City of Albuquerque Stormwater Construction Site Inspection Report

ESC File No.	A11E017	Project Name:	Unser/McMahonLots1 & 3-7		
NPDES Id. No.	NMIR1004PN	Location:	10745 Unser Blvd		
4/5/2023	Owner	Contractor			
Operator	Holly Partners LLC.	Insight			
Contact name & title	Yogesh Patel	James Romero Sup			
e-mail	yogi1020@gmail.com	James@insightnm.com			
Contact Phone #	275-8223	934-2511			
COA Inspector	Doug Hughes	Start/End Time:	10:30AM		
Construction Phase:	Building on lot 4 & both new and old disturbance on other lots				
Type of Inspection:	Regular	Storm Event	Post Storm Event >0.25"	311/Complaint	Follow Up
Weather at time of inspection?	Clear		Temperature: ~	45	
Estimated date of last storm 0.25" or greater	3/16/2023

ENGINEER'S SEAL	UNSER & McMAHON
		Unser Blvd & McMahon Blvd
		EROSION CONTROL PLAN
		SHEET #
		ECP-1
		JOB #
		2020015

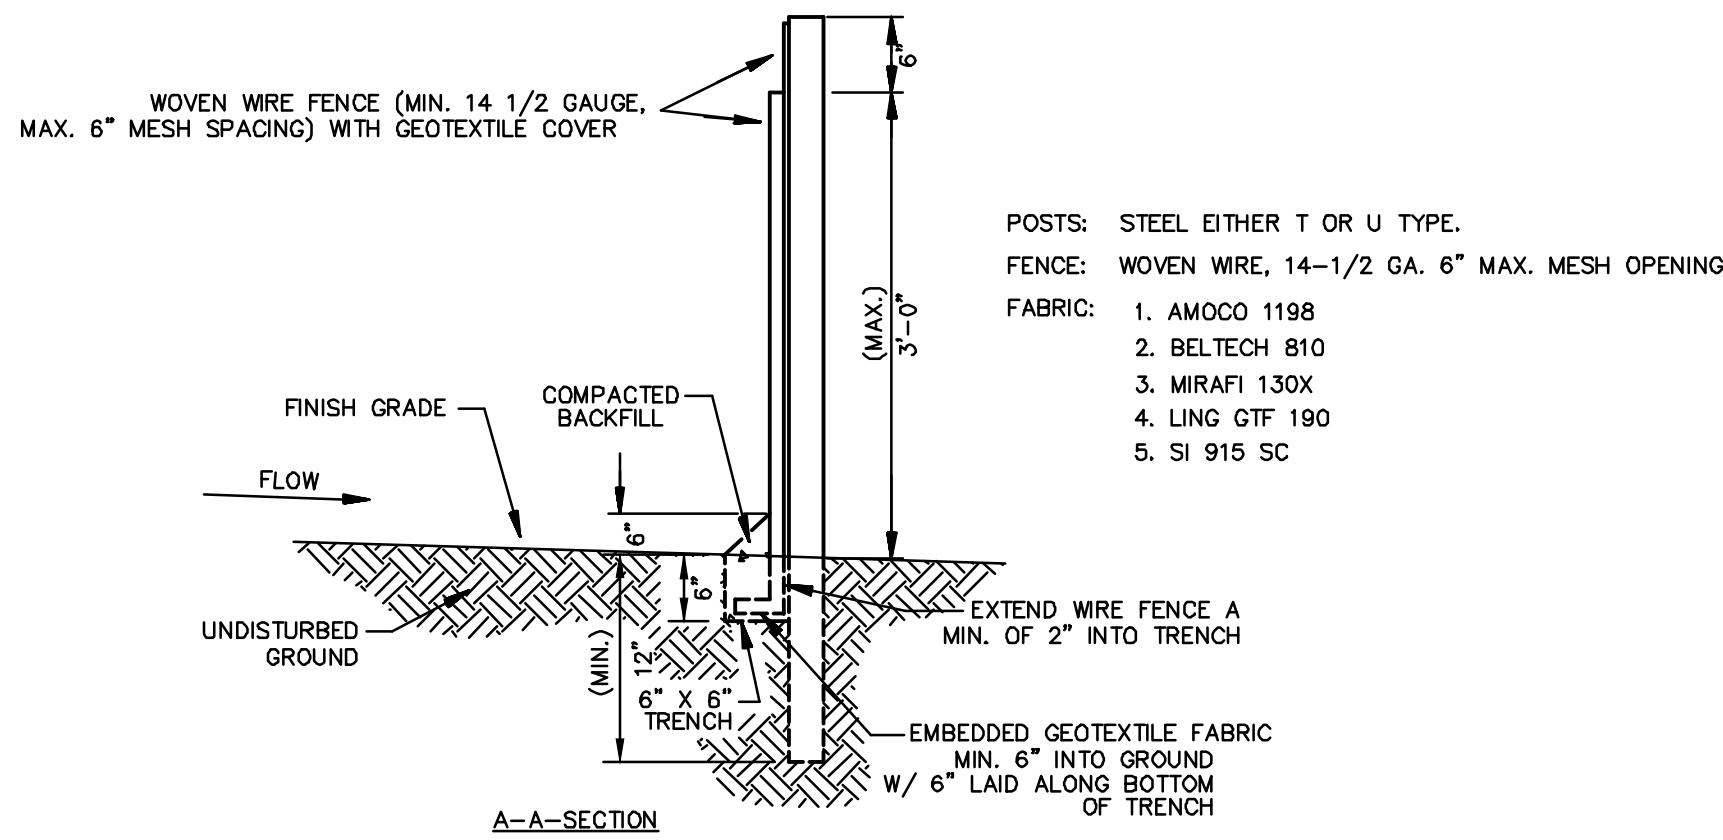
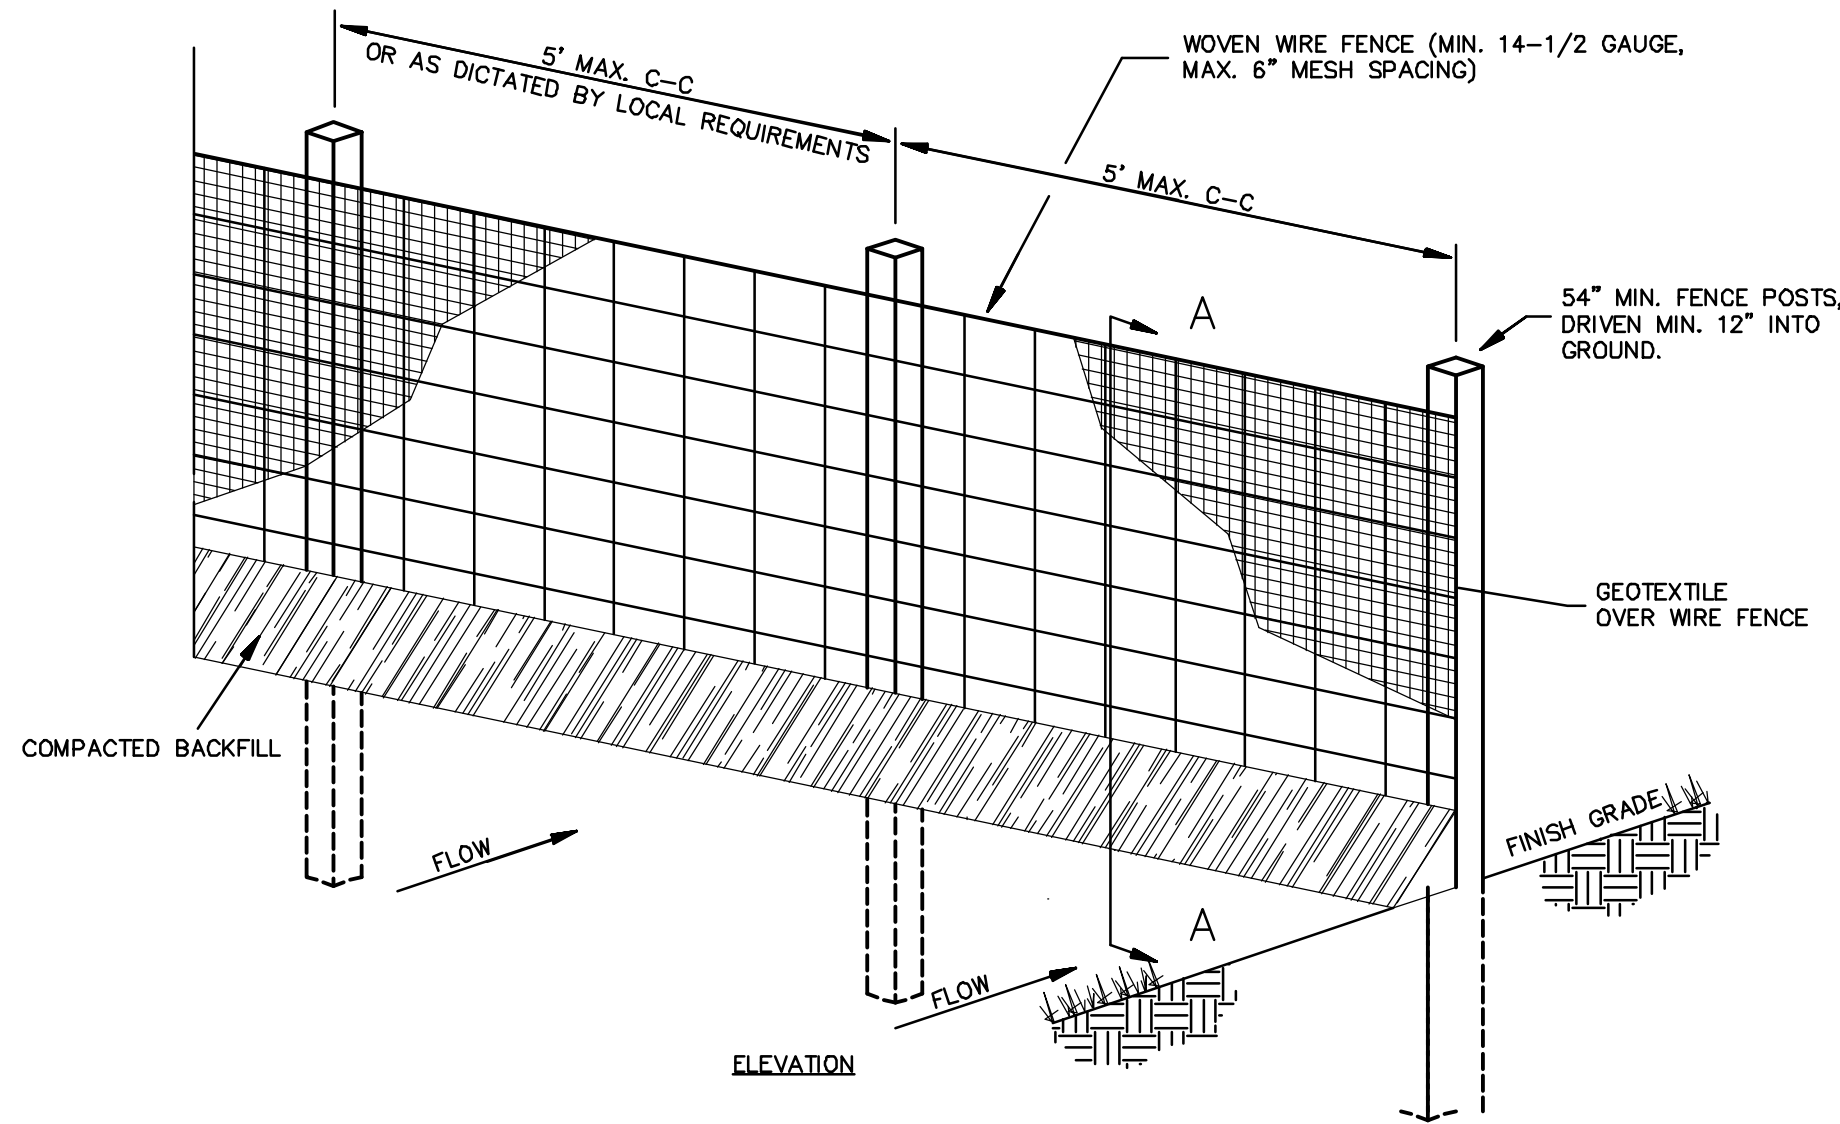
Item Number	Deficiency/ Corrective Action				
1	The Silt fence is full and the sediment must be removed. I recommend adding another Silt fence about 6' to 8' uphill from the existing silt fence leaving room to remove the sediment from the lower silt fence. CGP 2.2.3.c.i				
2	Sediment must be removed from the streets both onsite and from Unser and McMahon. Your contractor appears to be washing the street into the inlets as indicated by wet streets with no rain. Sediment must be picked up and removed not washed into the storm drains, CGP2.2.4.d				
3	Self inspection reports are missing since 2/15/23. Email signed copies of all missing reports to me.				
4	4. Concrete wash-water has been dumped on the ground in several places on lot 4 . All contaminated soil and dried concrete washout must be picked up and disposed into the waste containers. All future wash-water must be directed into lined containers.
